GORT PUBLIC REALM ENHANCEMENT PROJECT

AN COIMISIUN PLEANALA CASE NO. 323066-25

**GALWAY COUNTY COUNCIL RESPONSE TO
OBSERVATION BY:**

NATIONAL TRANSPORT AUTHORITY

PROJECT TITLE	GORT TOWN CENTRE		
PROJECT NUMBER	P3003160		
DRAWN BY	LANDSCAPE GENERAL	SCALE	@ A1
CHECKED BY	ARRANGEMENT	DATE	1:200
DATE	SHEET 6 OF 9	REVISION	16.08.23
PROJECT NUMBER	3160-BDP-00-XX-DR-L-0106	REVISION	P05

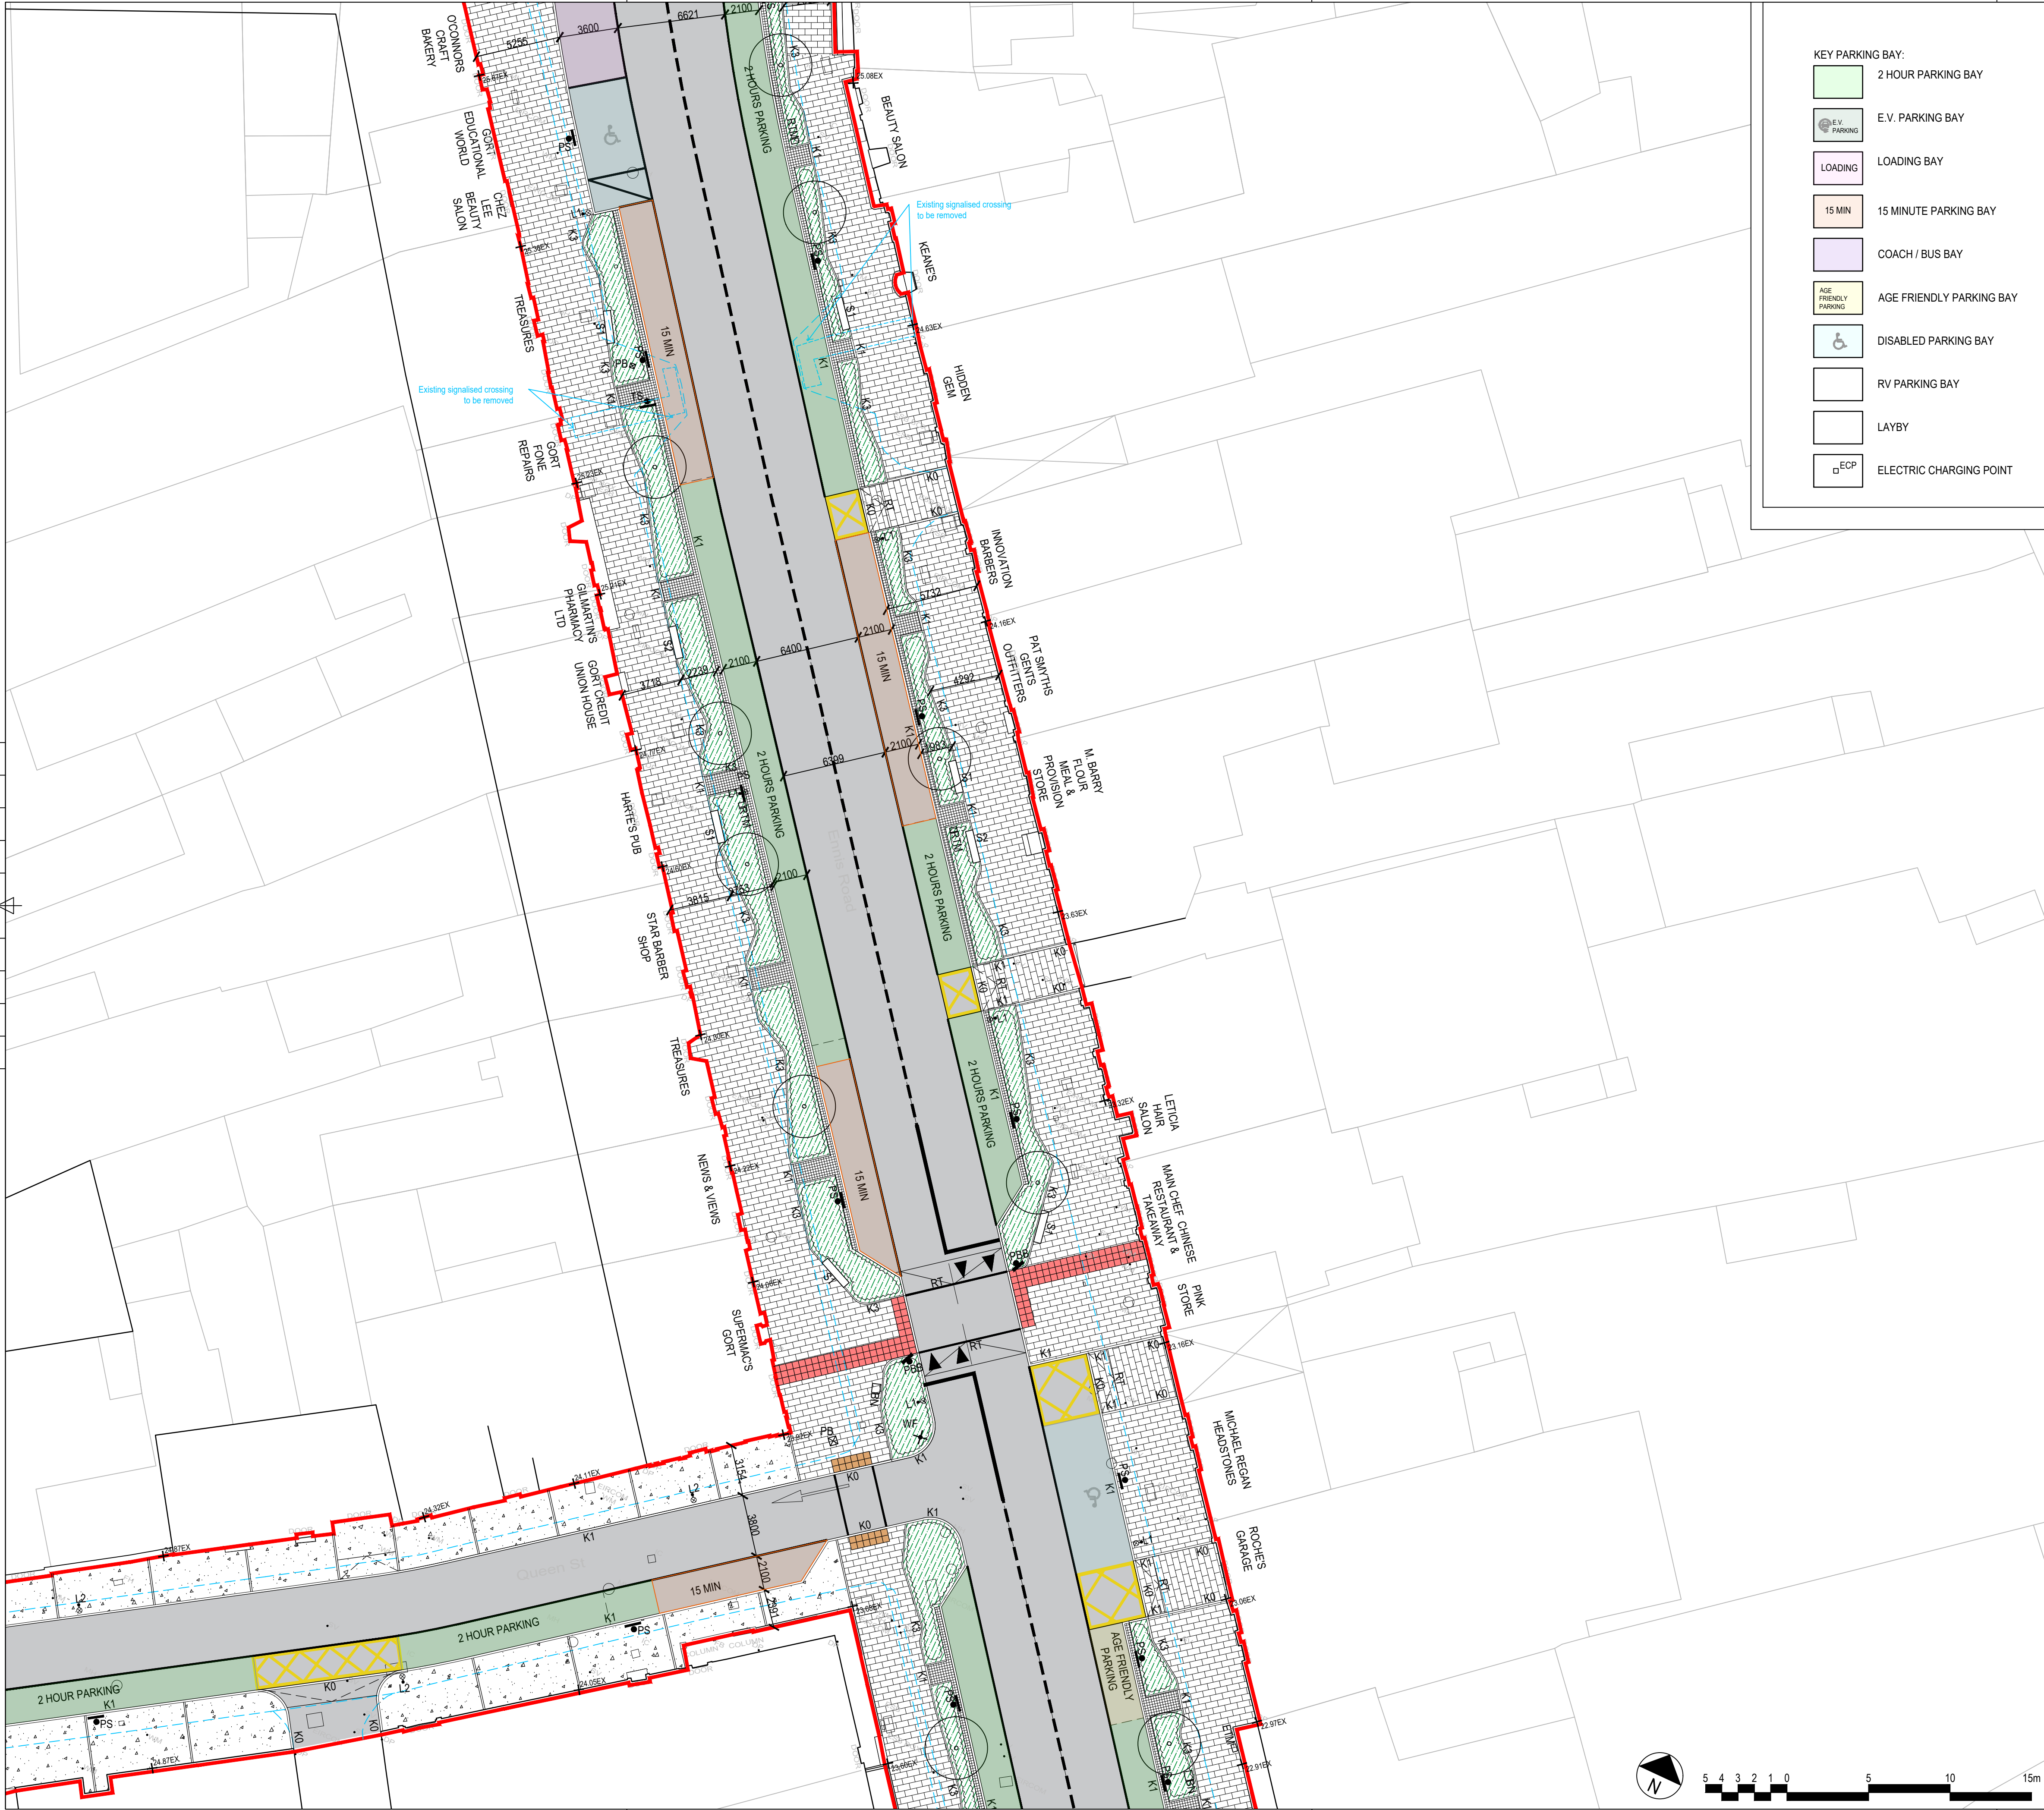
Galway County Council notes the NTA's emphasis on future capacity and flexibility. Our proposal for double bus bays and consideration of intermodal transfer zones is informed by Bus Éireann's recommendations and anticipated growth in demand. We propose ongoing engagement with the NTA and Bus Éireann to ensure that the final design is robust, adaptable, and future-proofed for the evolving needs of Gort. Unfortunately, the current bus stop locations cannot be enlarged to accommodate double bus bays and therefore the location shown in Galway County Councils Planning application was selected in close collaboration with the business community.

In order to meet Bus Éireann's need Galway County Council proposes to relocate the bus stops to a position where enlarged, double bus bays which can accommodate two busses simultaneously can be developed.

Image 1: The GCC Planning Application drawing DR-L-0107 which illustrates the provision of a double bus bay on the north bound service which allows for future growth of bus services.
